# Necton Parish Council (EN010079) Response to Additional Boreas Questions ExQ4, 28 April 2020

## Additional Question: Q4:9.2.1

### **The decision to use HVDC over HVAC transmission technology:**

**Title:**  
Scenario 2 - Onshore Infrastructure (1:25,000)  
(Map 9 of 9)

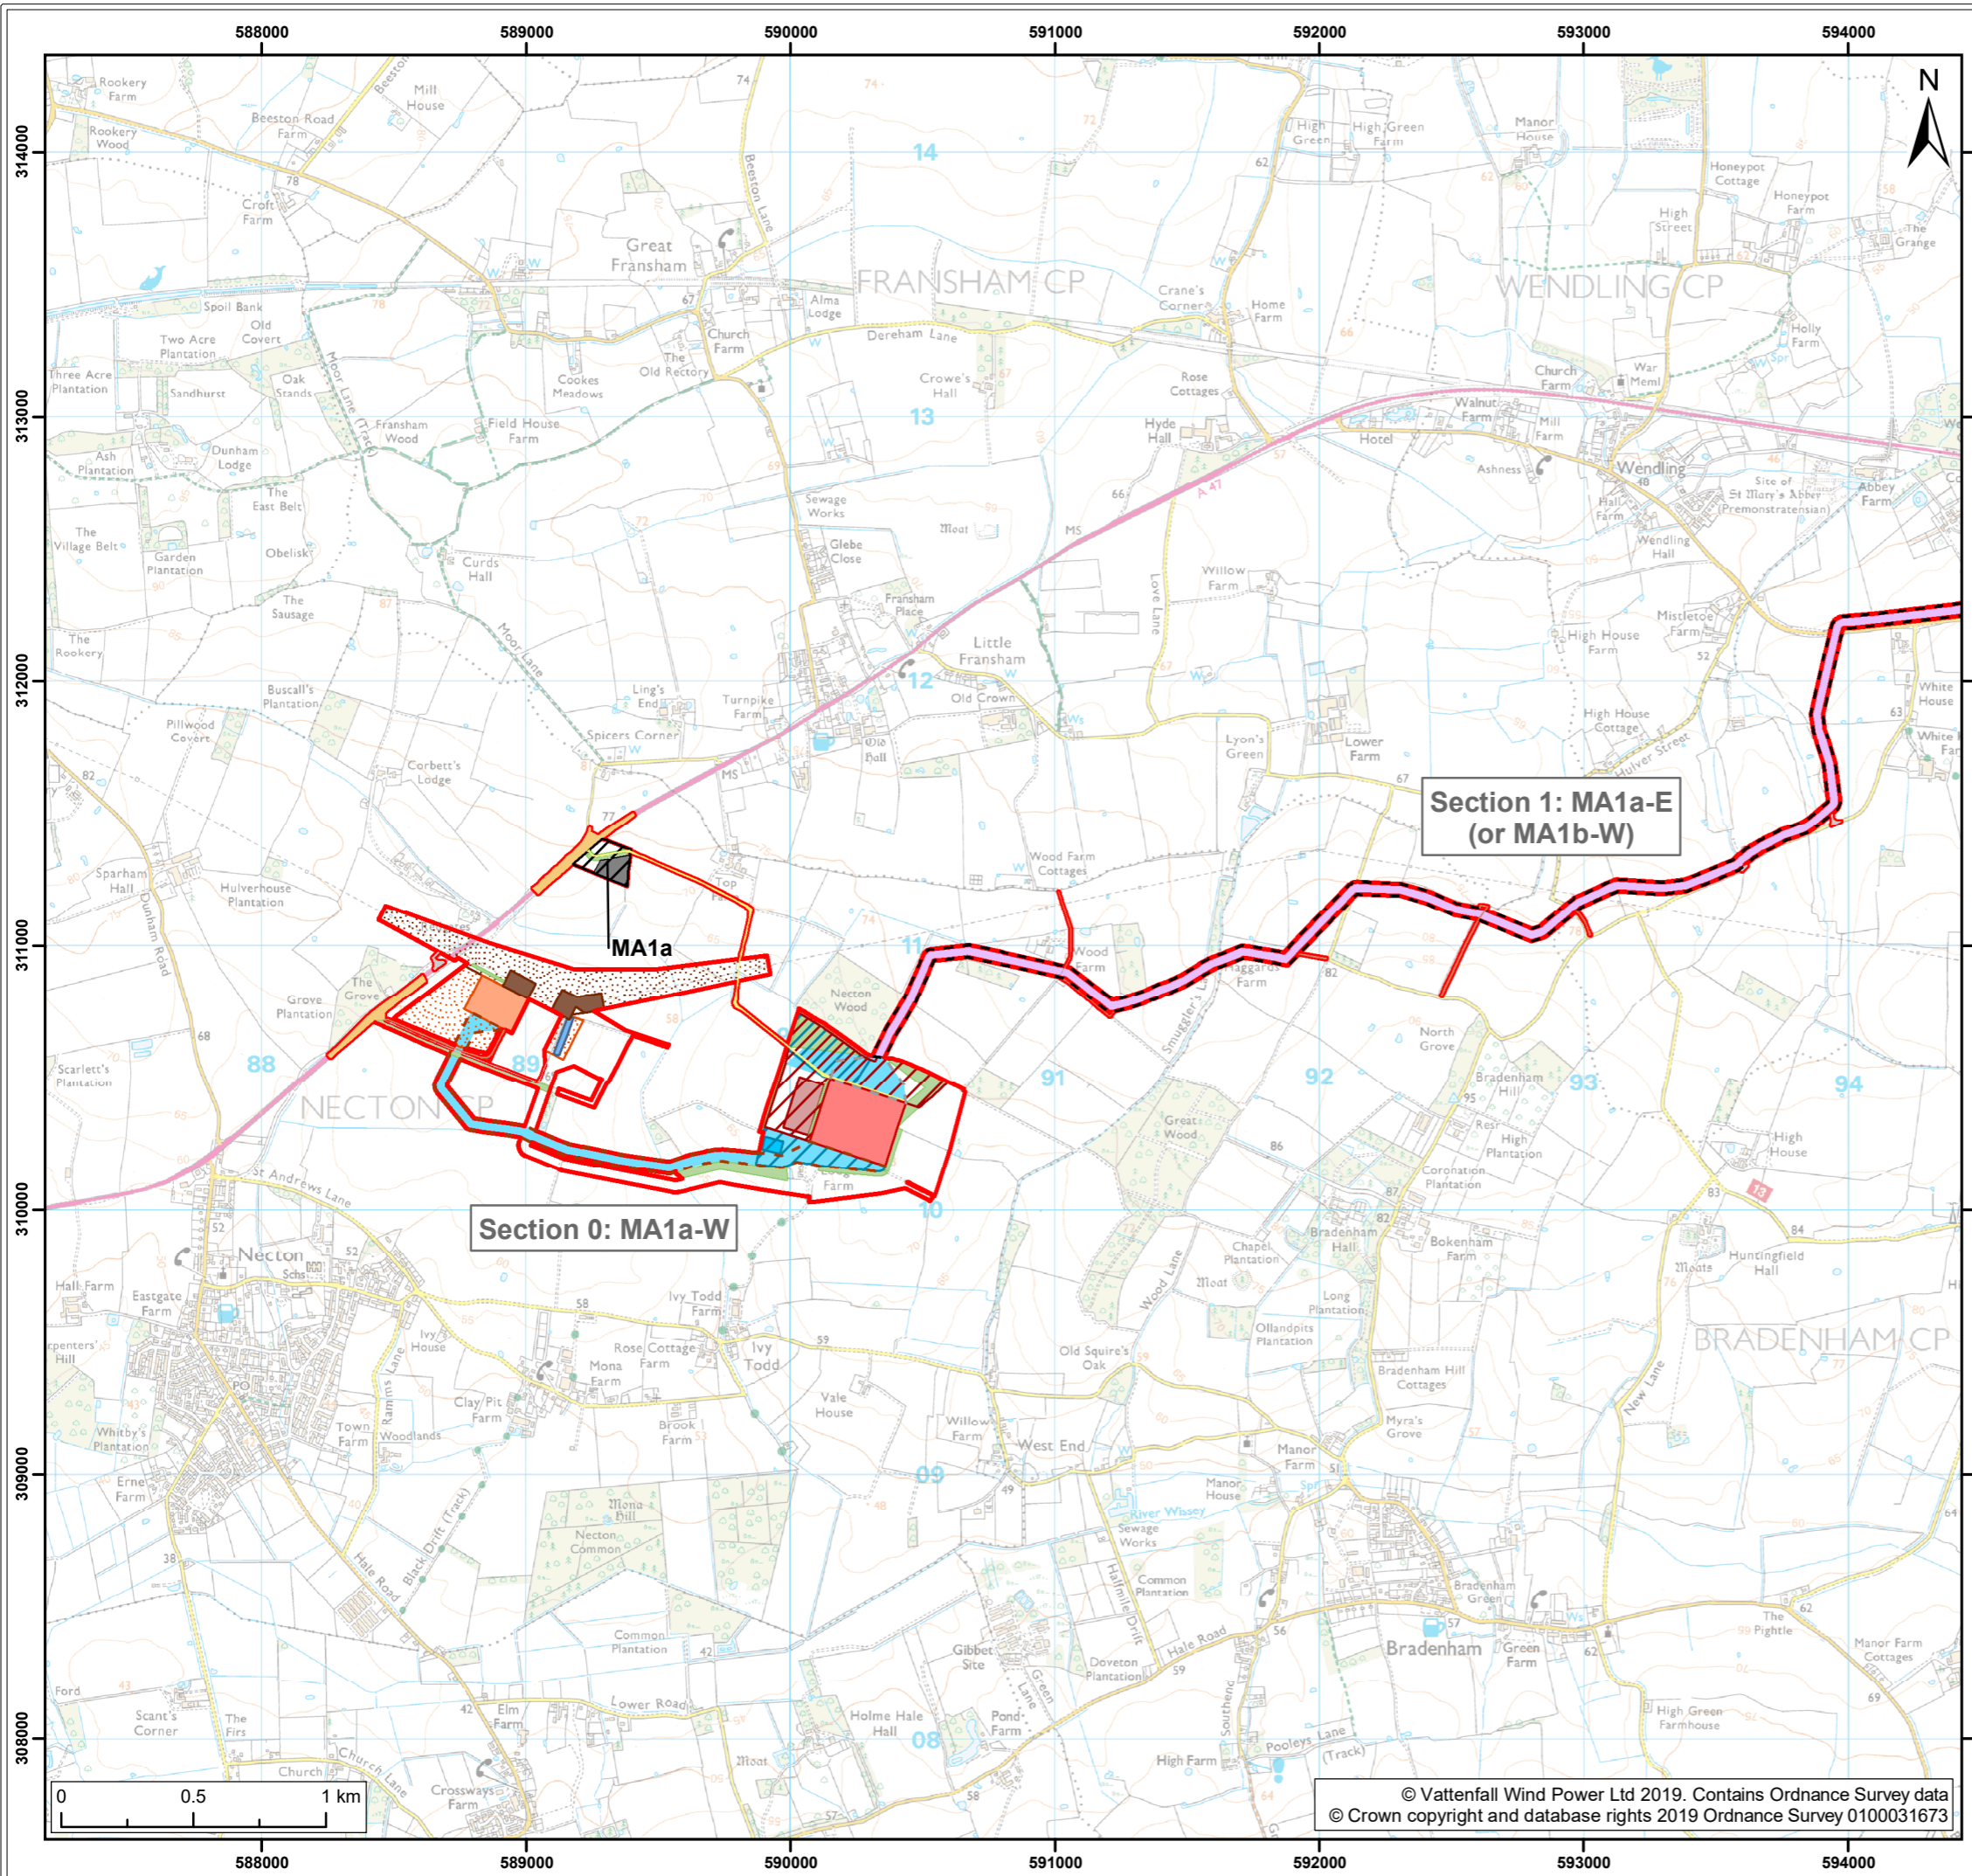
- a) A contribution to effective mitigation can also be made by specifying a lower ground level (datum) for the installations. NPC would like the ground level datums for the National Grid extensions and Converter halls to be set as follows:

#### **National Grid extensions:**

- 62 metres for the south east extension. Alternatively, the installation can follow the slope of the ground but cannot exceed 13 metres above ground level at any point.
- The north west extension to use the same datum level as the Dudgeon substation.

The height of the National Grid extensions to be limited to 13 metres above the applicable datum level.

**Converter halls** datum level to be set at the 65 metre contour line. All buildings higher than 13 metres above the datum should be sunk into the ground such that their height above the datum does not exceed 13 metres.

Photomontage of the proposed Norfolk Boreas HVDC Substation with the National Grid Substation Extension and mitigation planting (15 years growth)

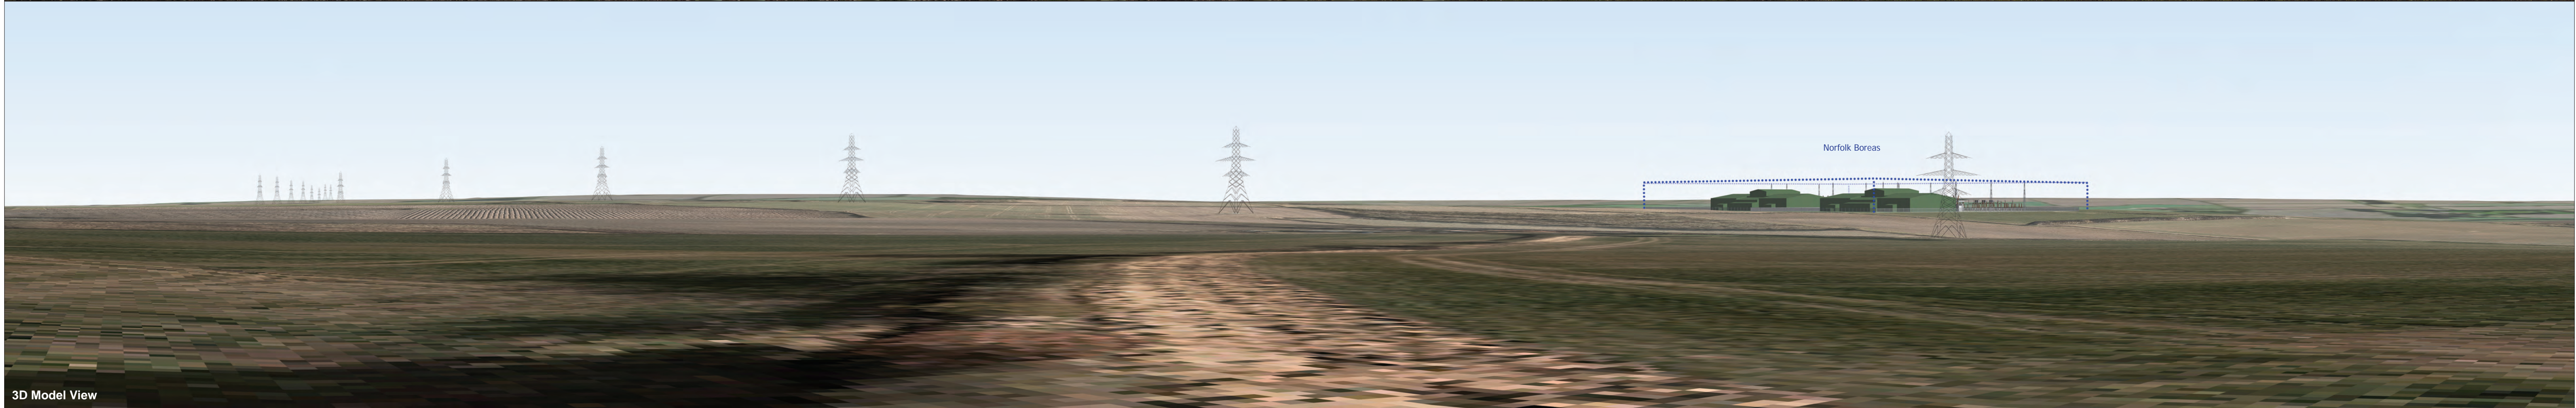
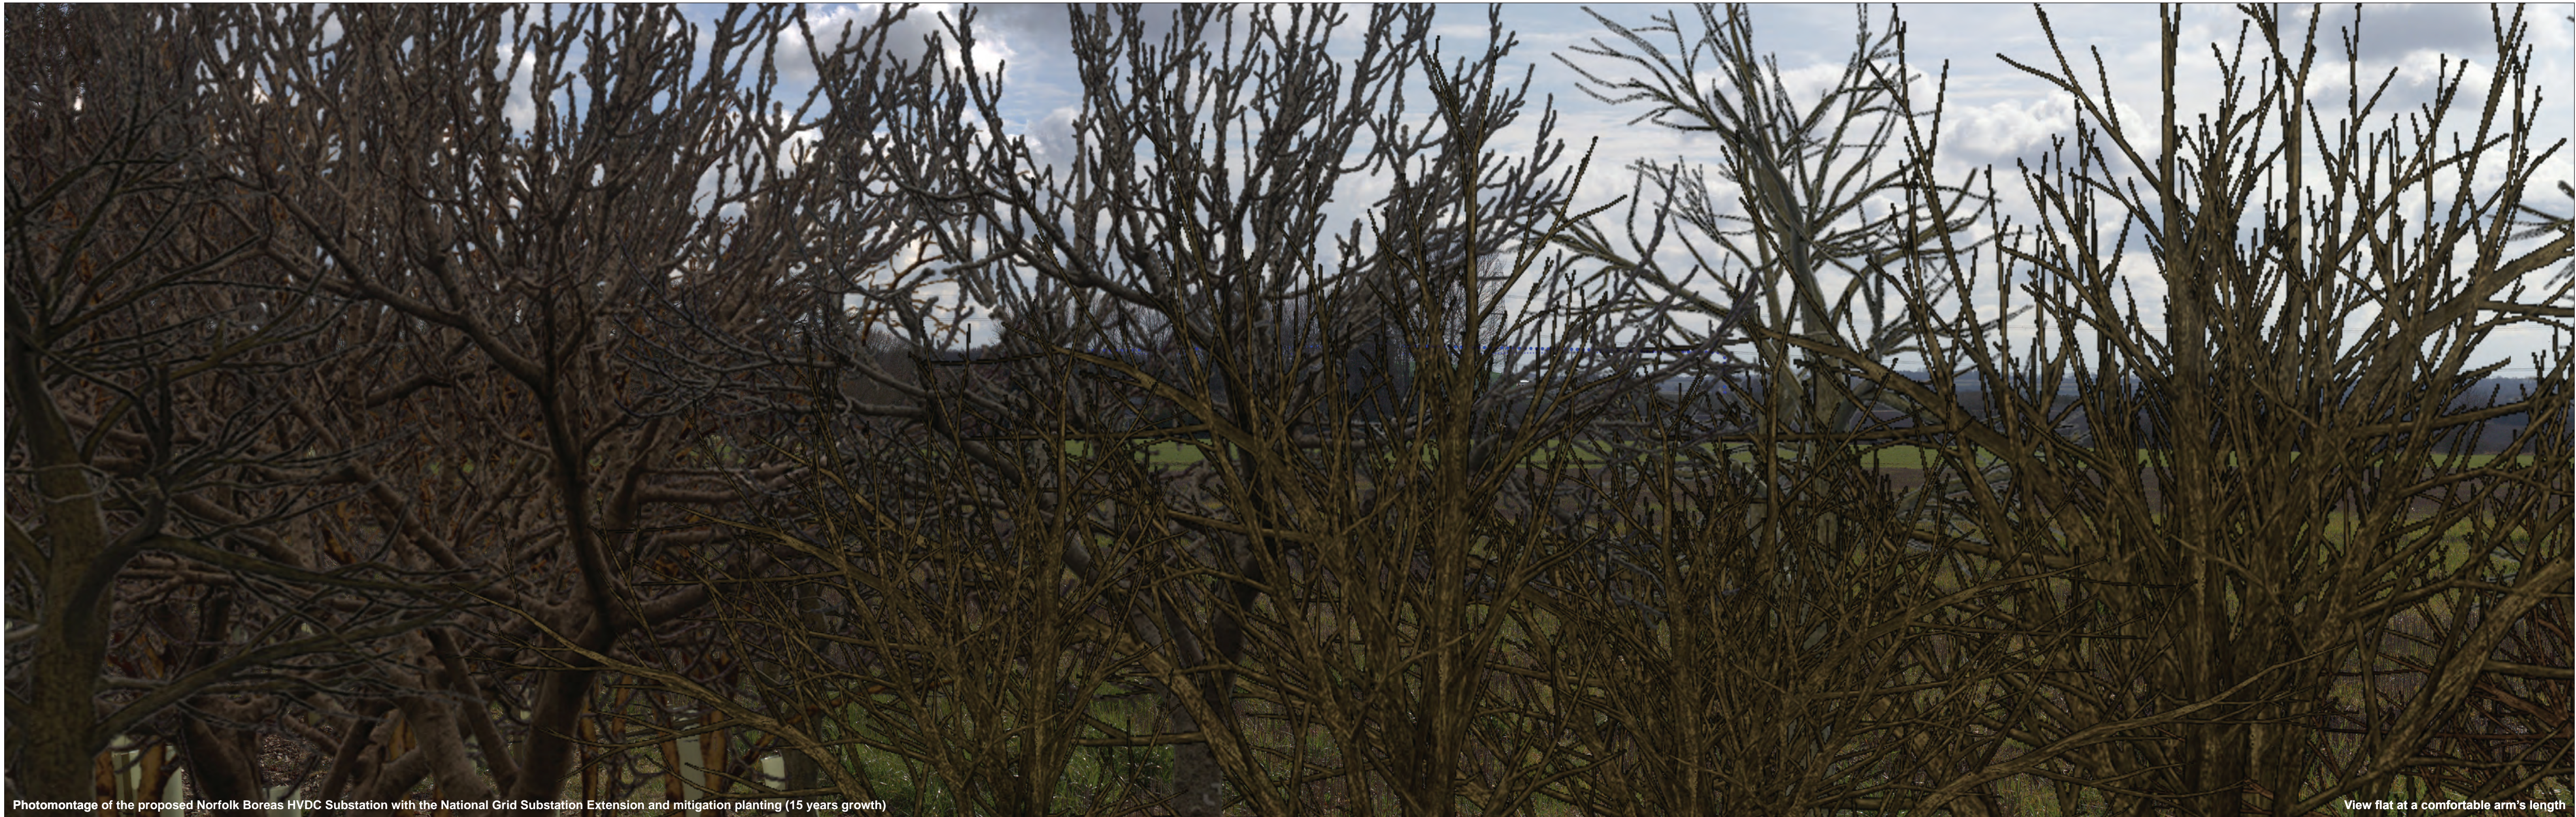
*All those who consider Top Farm to be a more suitable location for the onshore project substation for the Proposed Development are asked whether they would retain that opinion if the SoS were to consent the Norfolk Vanguard OFW, with its onshore project substation on the site indicated for the Proposed Development's Scenario 1, as shown on Norfolk Boreas drawings eg [REP7-019, Figure 1b].*

Since the same information was made available to both examining authorities (ExAs) and the accompanied site visits of both ExAs included Top Farm, the conclusions reached by both ExAs ought to be the same. If that's not the case, the Secretary of State has the final say and one would hope that he will apply sense to the decision and ensure a single location is selected. If all that fails, Necton Parish Council (NPC) would prefer as much as possible of the huge infrastructure to be placed as low as possible in the landscape. Top Farm is therefore the preferred location for Boreas whatever recommendation is made by the ExA for Vanguard. In addition, NPC would ask that if the ExAs come to different conclusions, an internal investigation be undertaken to understand why the Vanguard ExA did not reach the same conclusion as the Boreas ExA given that the same information was available to both ExAs.
